CITY OF ALBUQUER

April 16, 2015

RE: **Chaparral Elementary School Portable Relocation** Grading and Drainage Plan Plan Dated 4-14-15 (File: F10-D005)

OVERALL GRADING & DRAINAGE PLAN

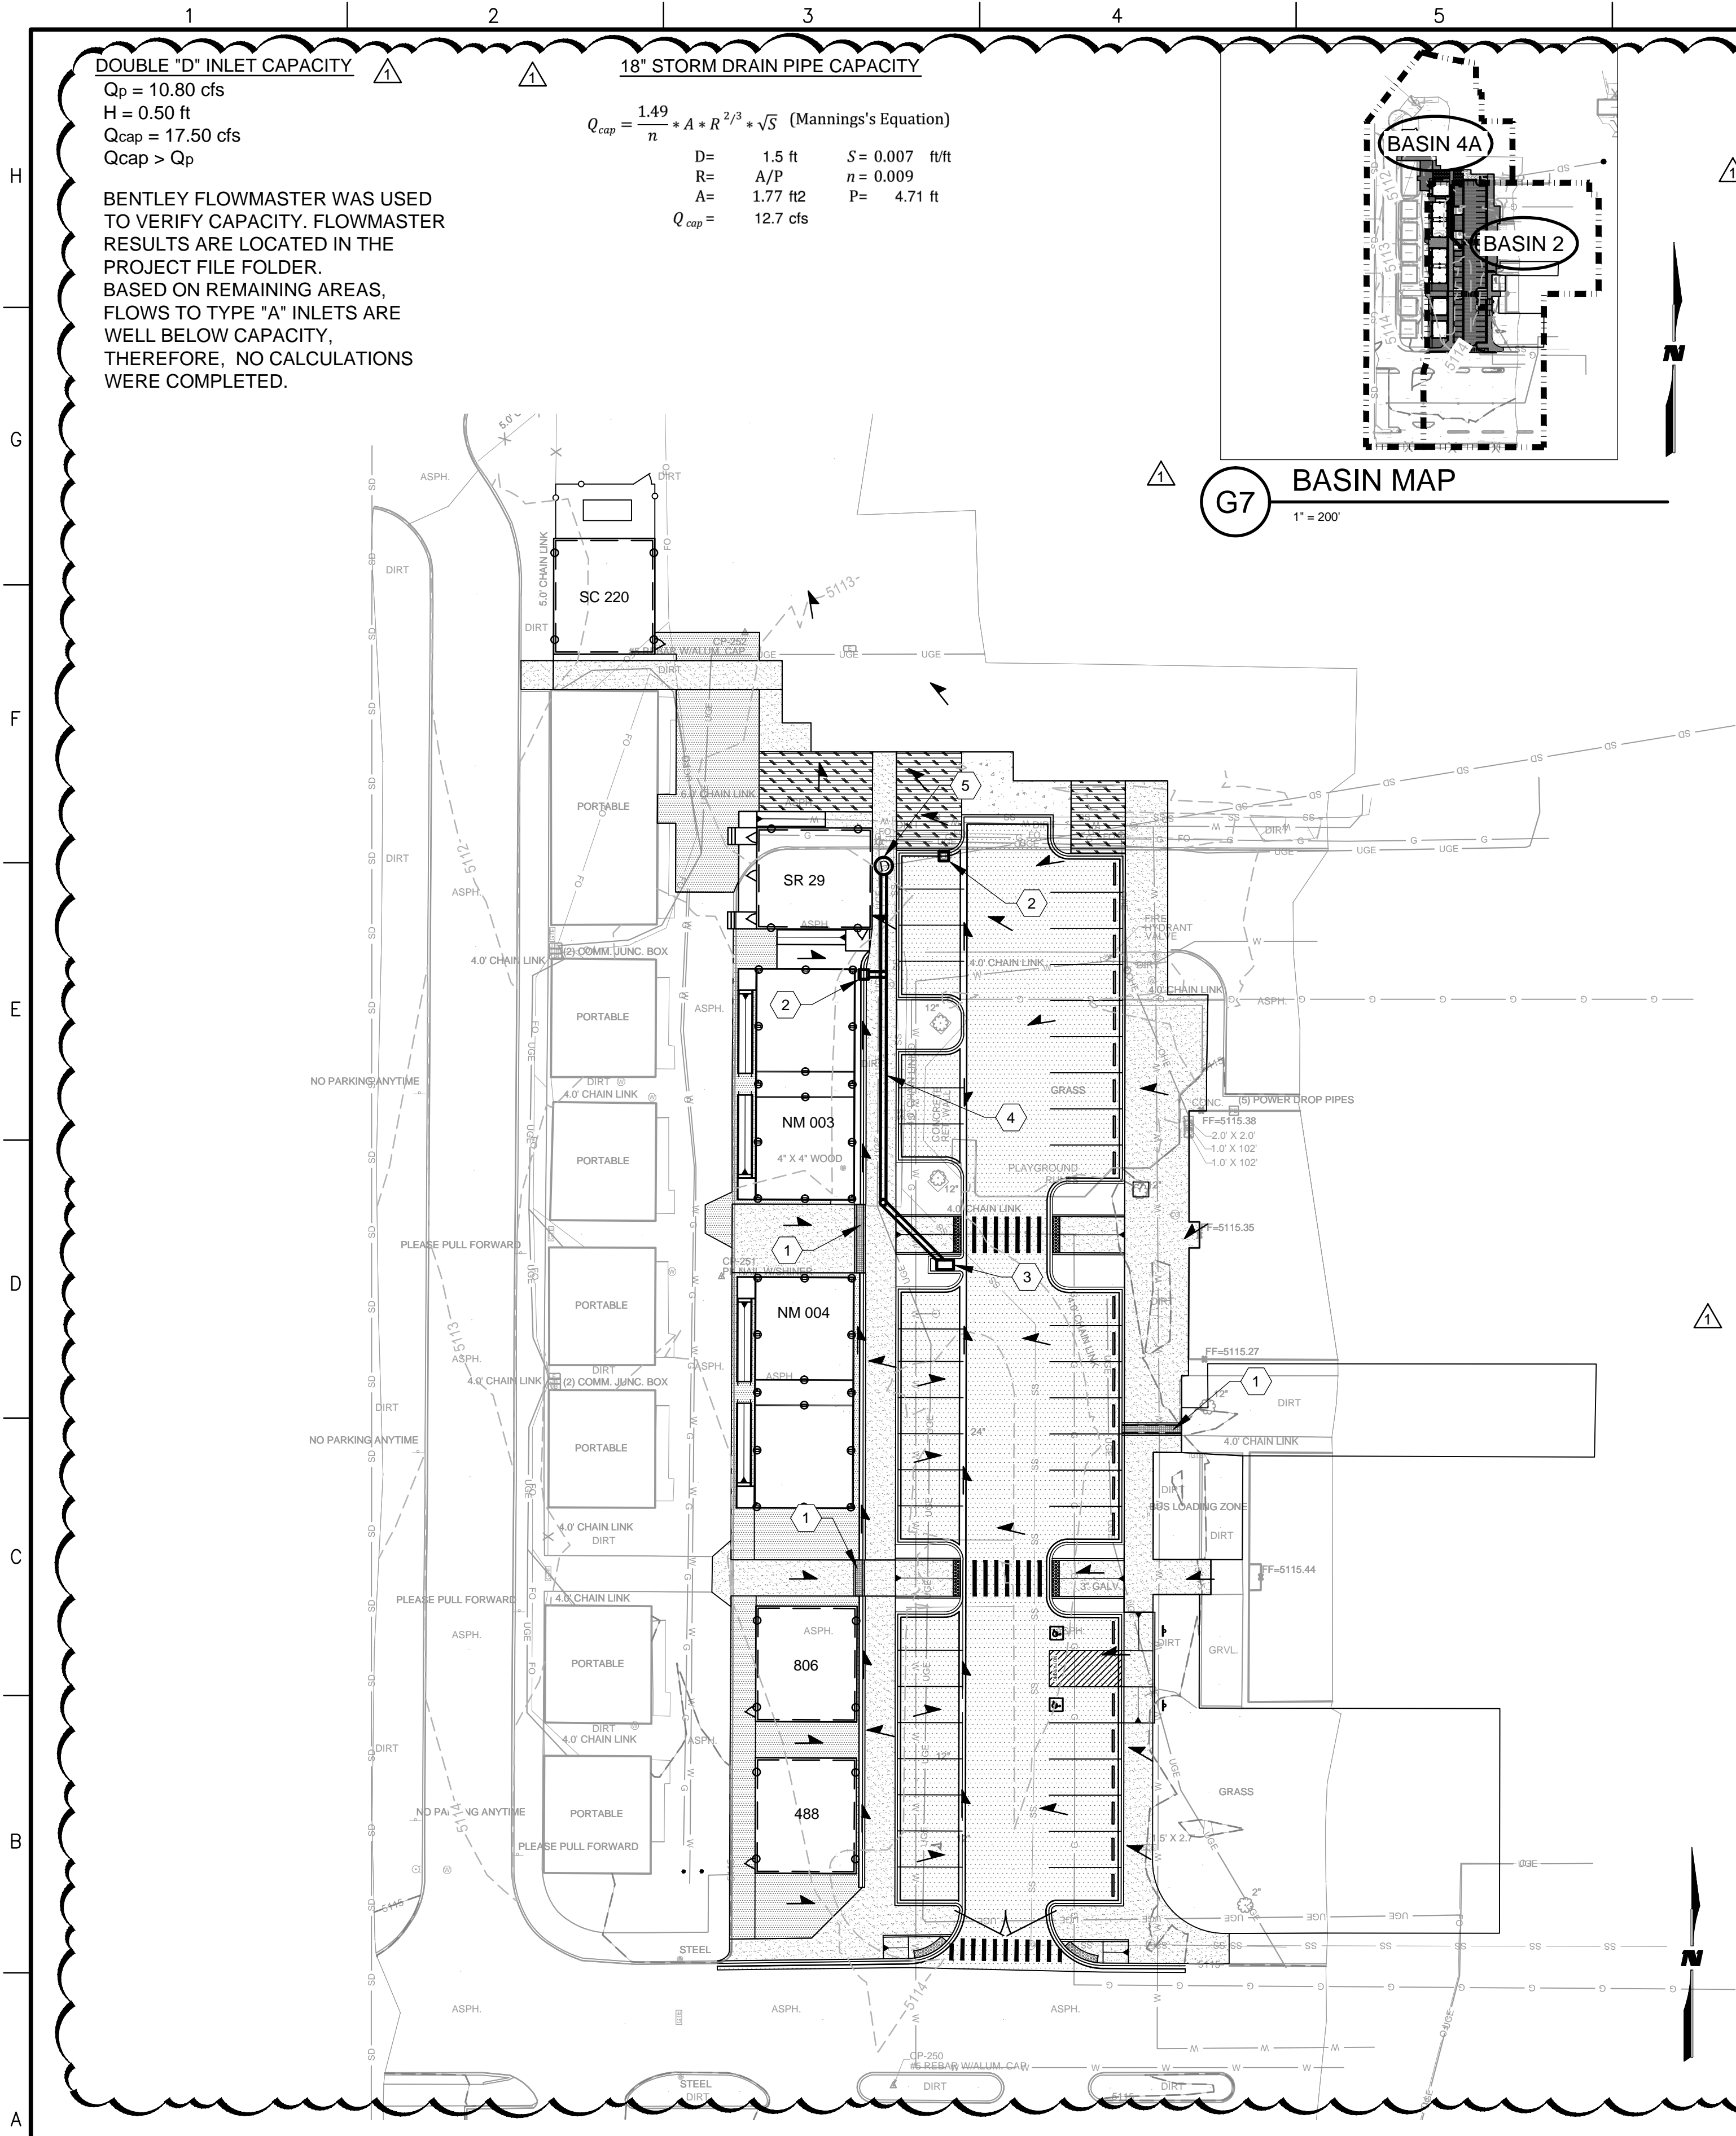
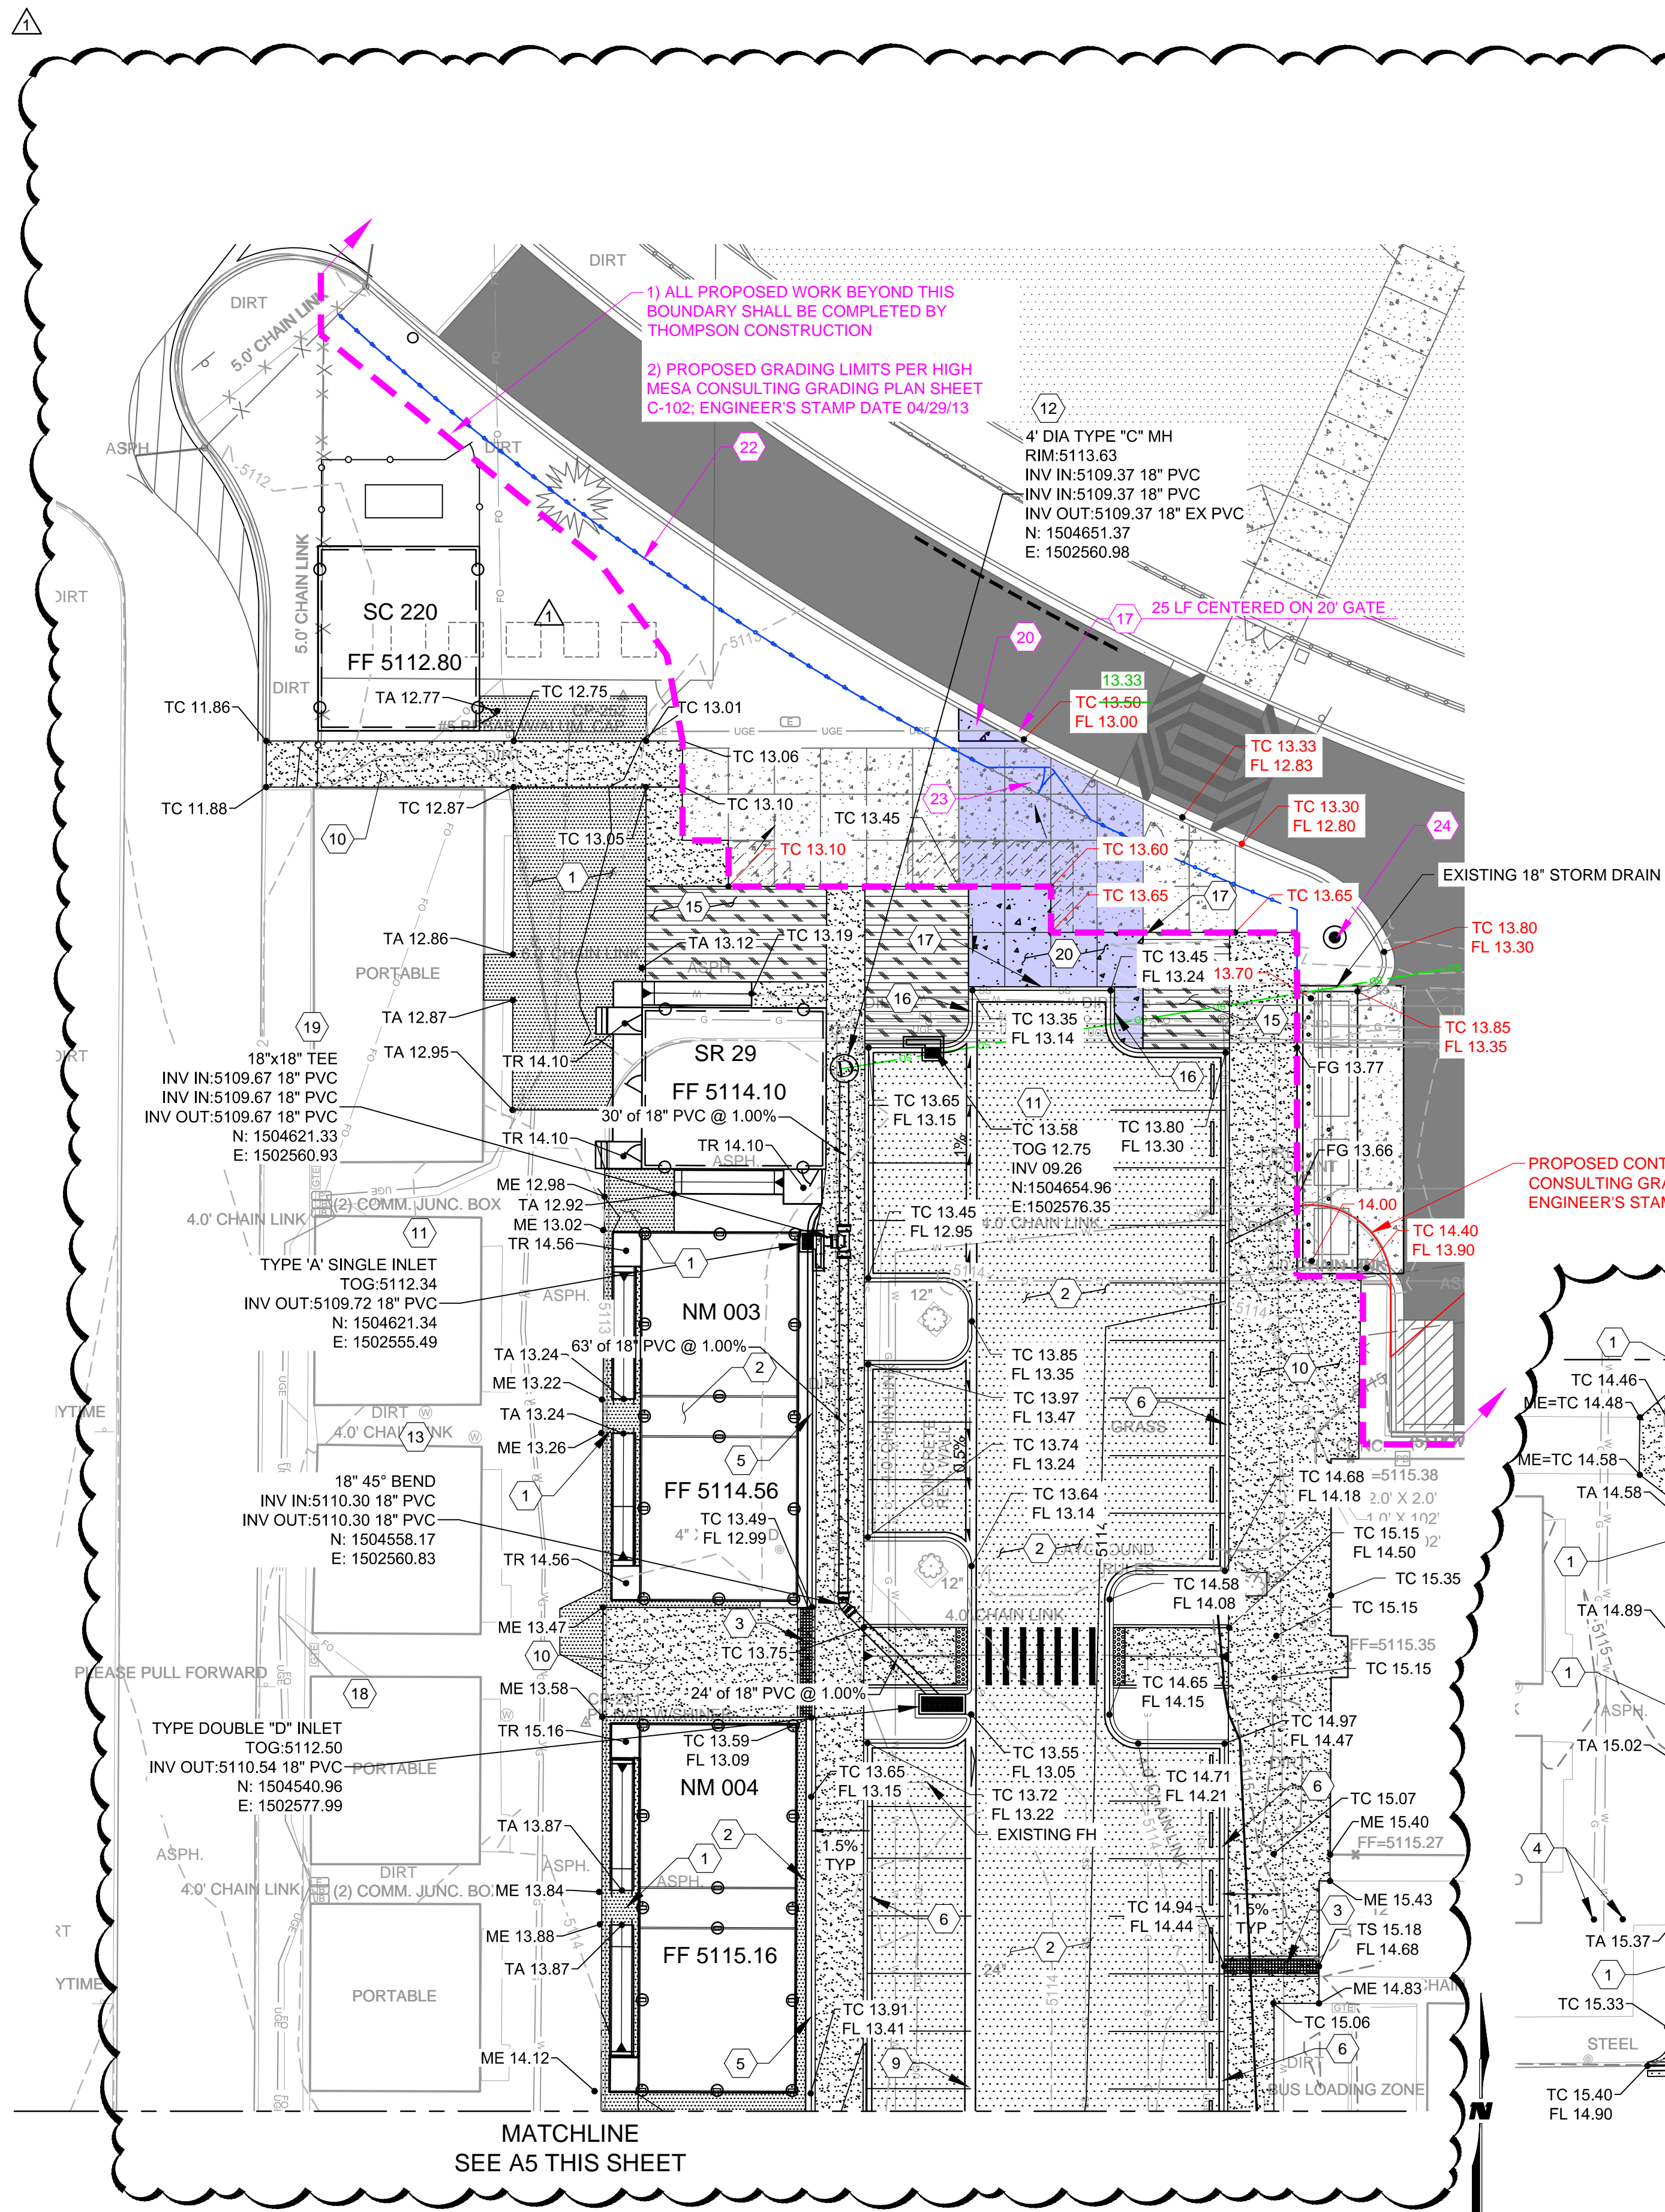
1) Please indicate how the first flush volume is to be managed which is defined as 0.34" times the additional impervious area for the site. Show first flush computations on the plan.

2) For all proposed pipe inlets and sidewalk culverts, show amount of flow that is captured and the capacity to handle the flow.

- 3) Label existing 18" storm drain pipe on the plan view and the proposed discharge of 11.94 cfs.
- 4) Show direction of runoff flow from the roofs of the portable buildings and any roof drains for the portable buildings. If there is any roof flow directed to the west of the New Mexico 87103 building, show how the flow is to be managed. Show how the roof flow for the three northernmost portable buildings is being managed and if it is being conveyed to the new on-site storm drain with additional information which may include additional spot elevations, and/or inlets.
